### FORMAL OBSERVATION / OBJECTION

Re: Proposed Carrow Wind Farm Strategic Infrastructure Development

An Coimisiún Pleanála Case Reference: PAX91.324164

Location: Townlands of Carrow, Moheragh and Gortaderry, Co. Tipperary

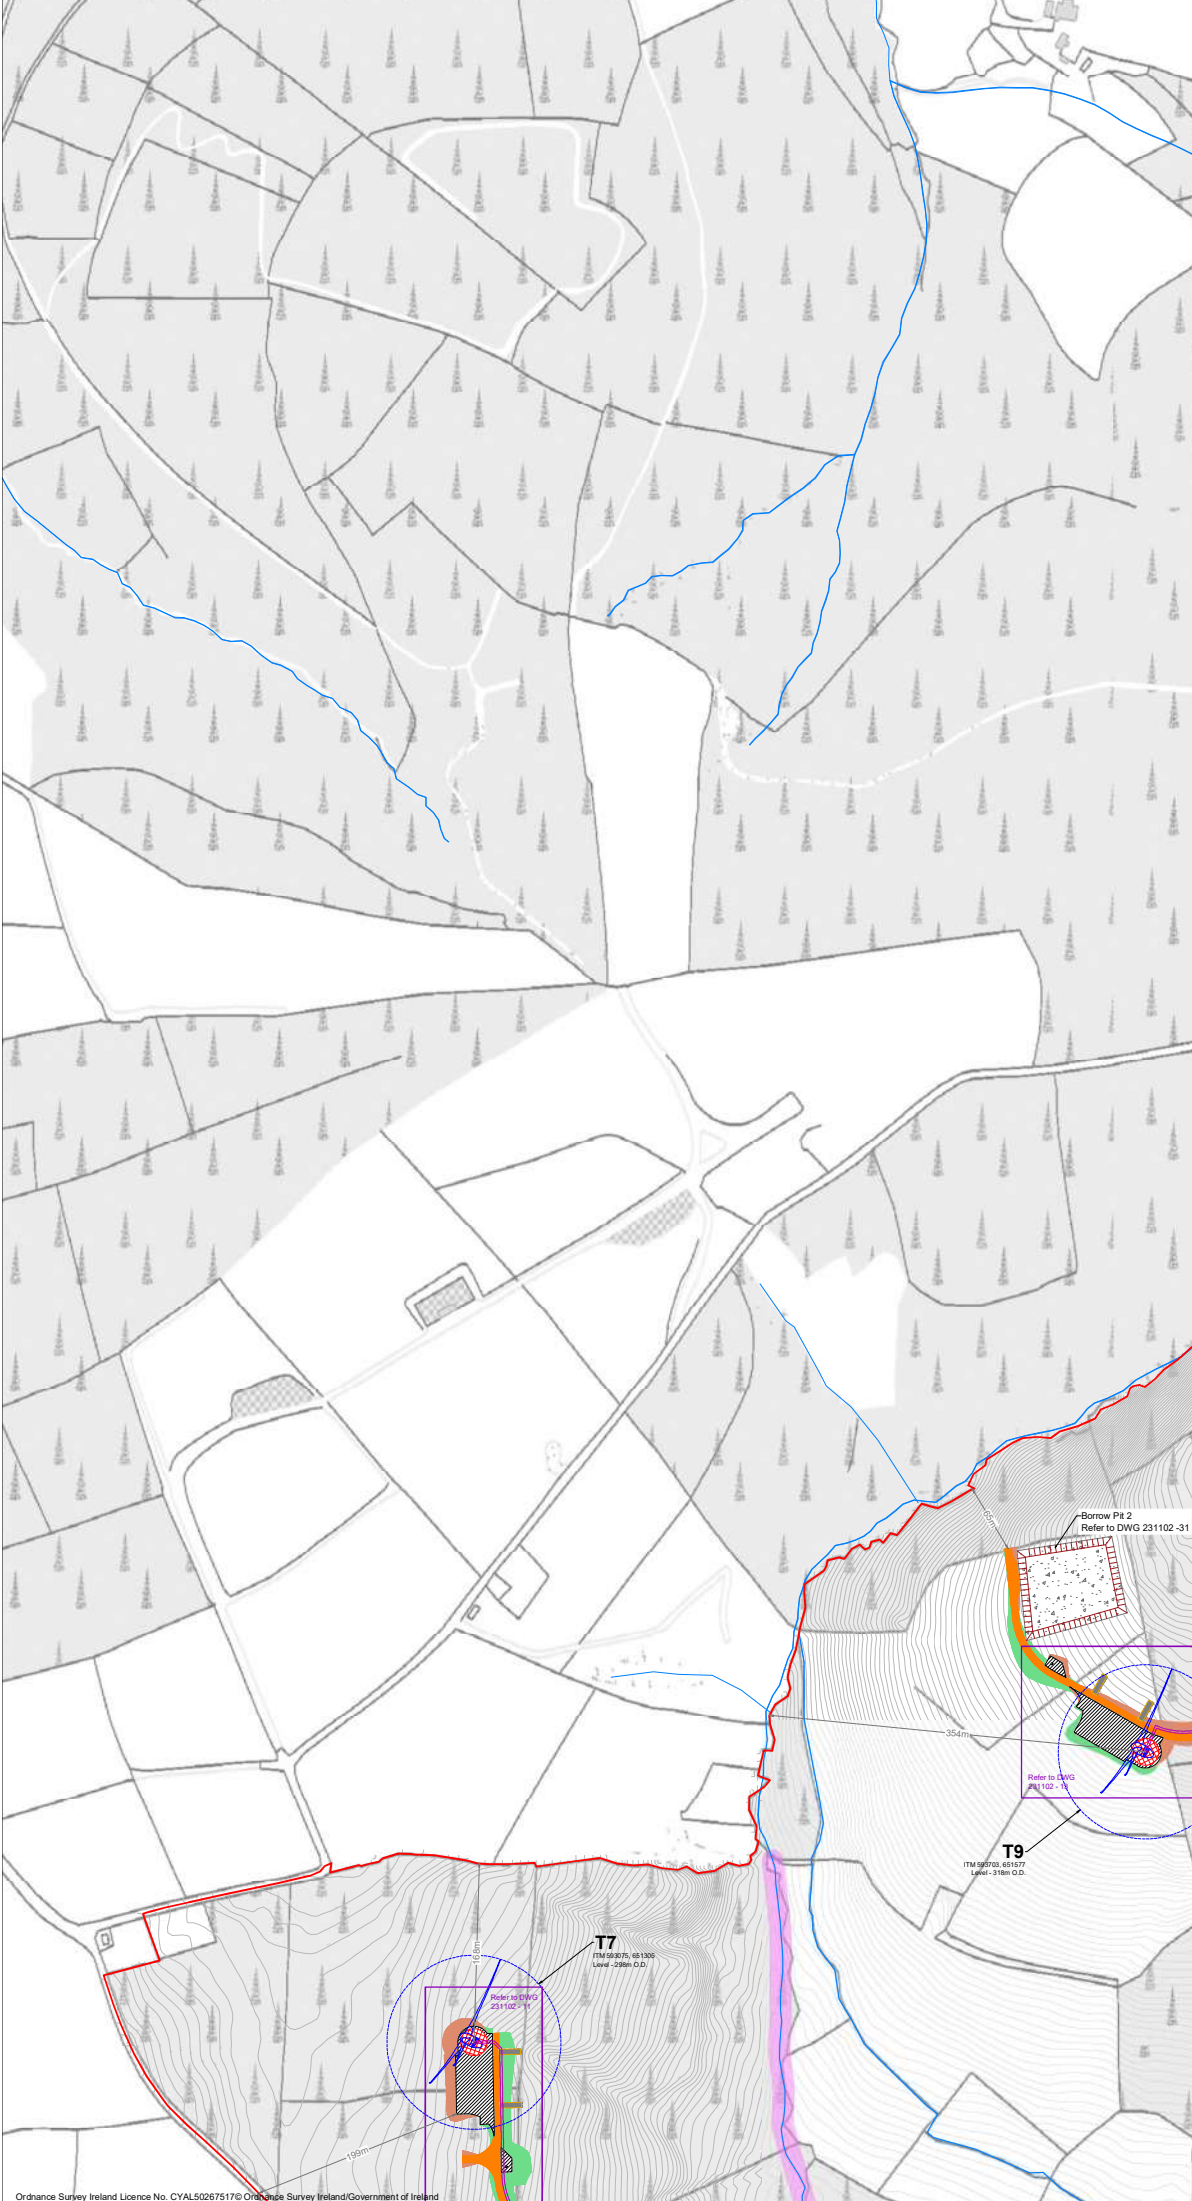
I also wish to raise serious concerns regarding the apparent proximity of proposed infrastructure and turbine activity to the local water reservoir and tank infrastructure located between Turbine T12 and Turbine T1, as shown on the submitted site layout plans.

The application documentation does not clearly demonstrate what assessment has been undertaken regarding risks to the local water supply infrastructure, whether vibration, excavation, blasting, heavy construction traffic, or drainage alterations could affect the integrity of the reservoir system, and what contingency protections are proposed in the event of contamination, sediment runoff, fuel spillages, or hydrological disturbance.

The Board should require clear and independently verified evidence demonstrating that the proposed development poses no unacceptable risk to the security, safety, operation, or quality of the local water supply infrastructure before any consent is considered.
